CITY OF ALBUQUERQUE

Re: John 23 Kitchen, 4831 Tramway Ridge Dr NE,
Request for Permanent C.O. –Accepted
Engineer's Stamp dated: 9-24-12, (F22/D011A1)
Certification dated: 5-6-13

**Re: John XXIII Catholic Community
Grading and Drainage Plan
Engineer's Stamp dated 9-24-12 (F22/D11A1)**

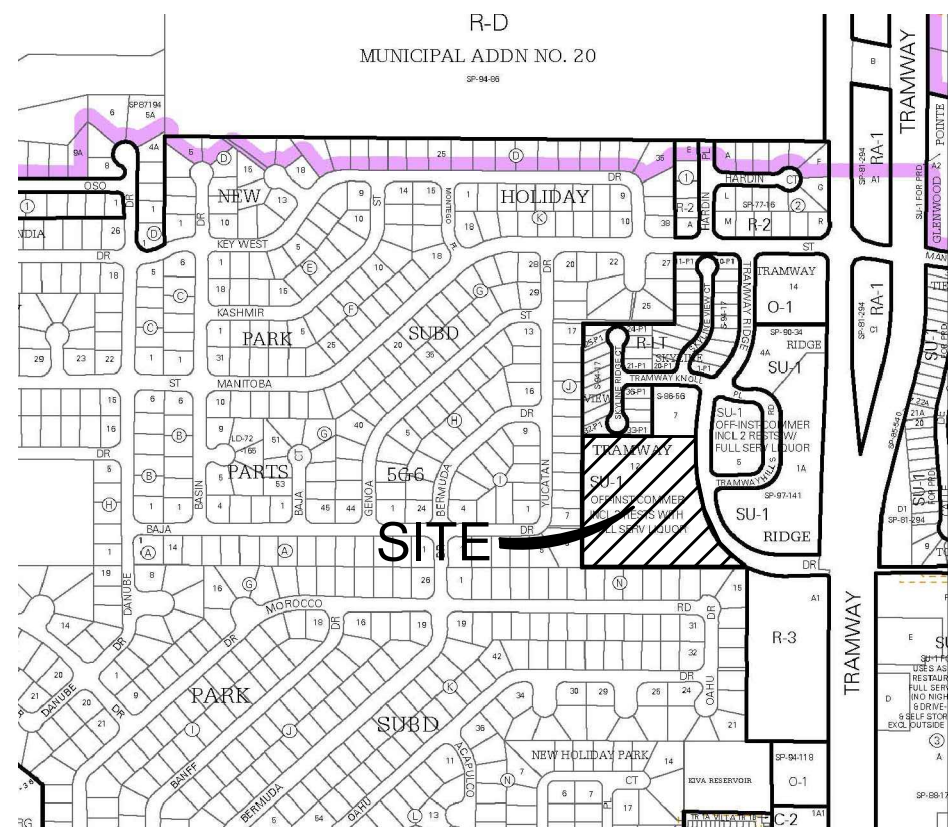
- Hydraulic calculations are needed for the site. How will this addition affect the flow of the pond?
- It appears that the pond has been filled and the outflow 6" pipe and emergency overflow are no longer present. Please verify.
- What type of addition is this?
